Our Ref
S/AR/2010/139
Date

Proposal: Detached Garage.
Site: Field House, The Thatchway, Angmering, Littlehampton, West Sussex
BN16 4HJ.
A/139/10/

Southern Water has no objections to the above proposal.

DRG. NO. 3221/3

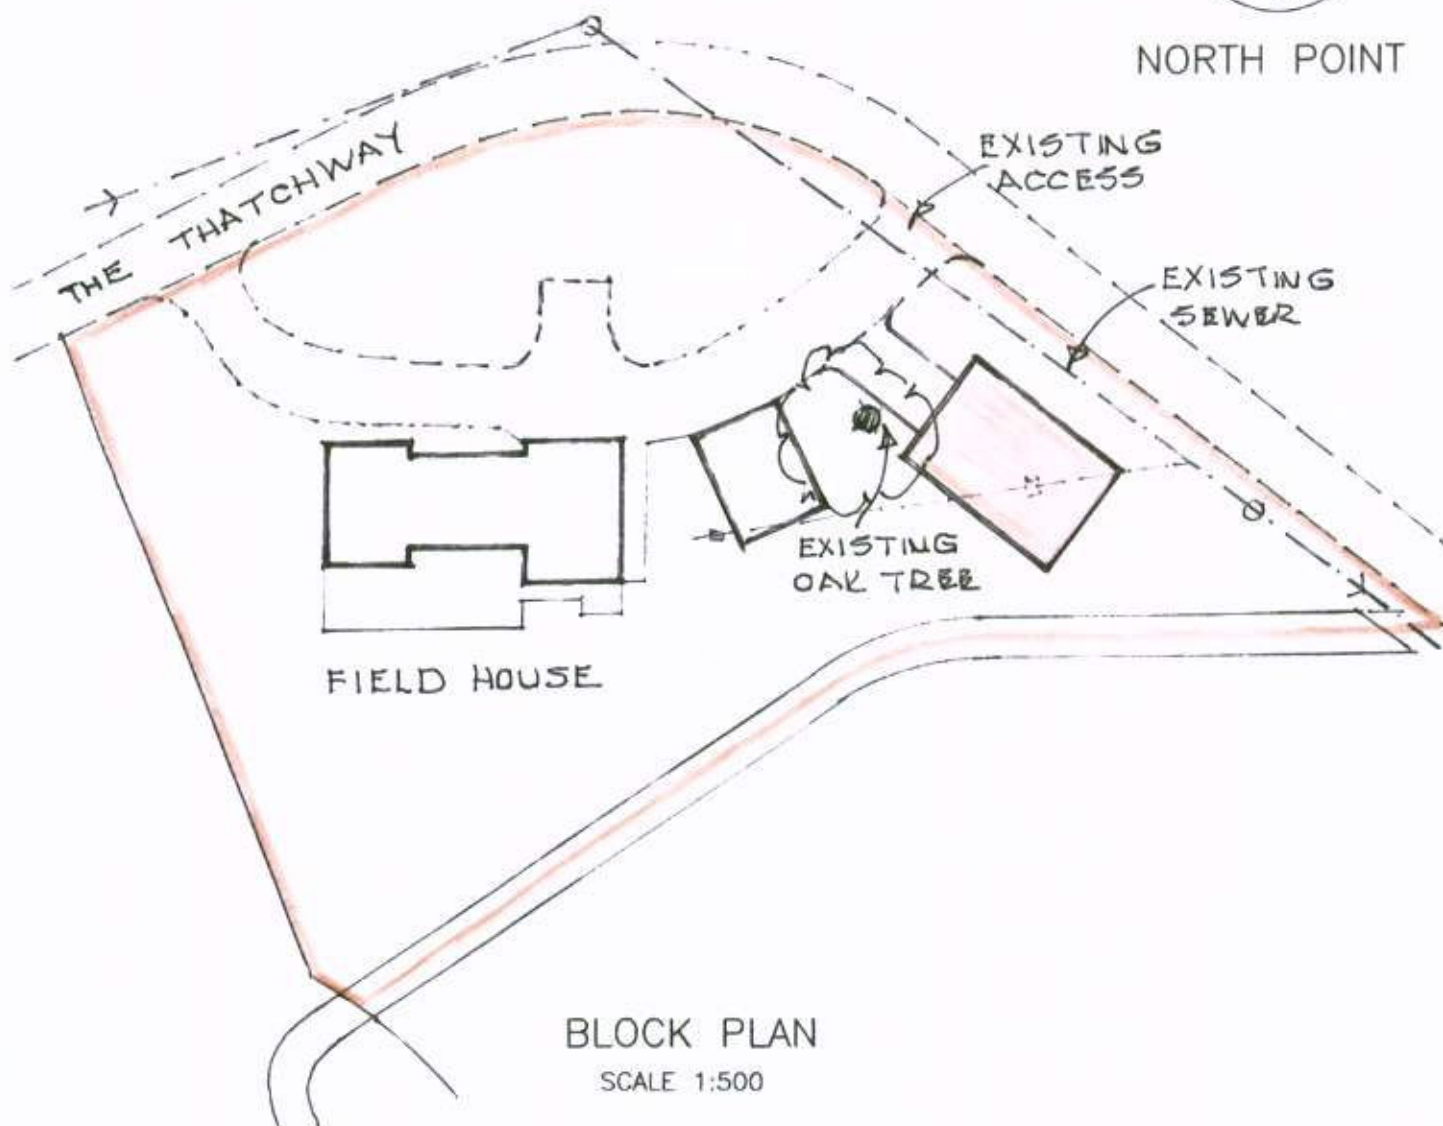
Please find attached a plan of the sewer records showing the approximate position of a public sewer crossing the site. The exact position of the public sewers must be determined on site by the applicant before the layout of the proposed development is finalised. Please note:

- No development or new tree planting should be located within 3 metres either side of the centreline of the public sewer.
- All existing infrastructure should be protected during the course of construction works.

In order to protect drainage apparatus, Southern Water requests that if consent is granted, a condition is attached to the planning permission. For example "The developer must advise the local authority (in consultation with Southern Water) of the measures which will be undertaken to protect the public sewers, prior to the commencement of the development".
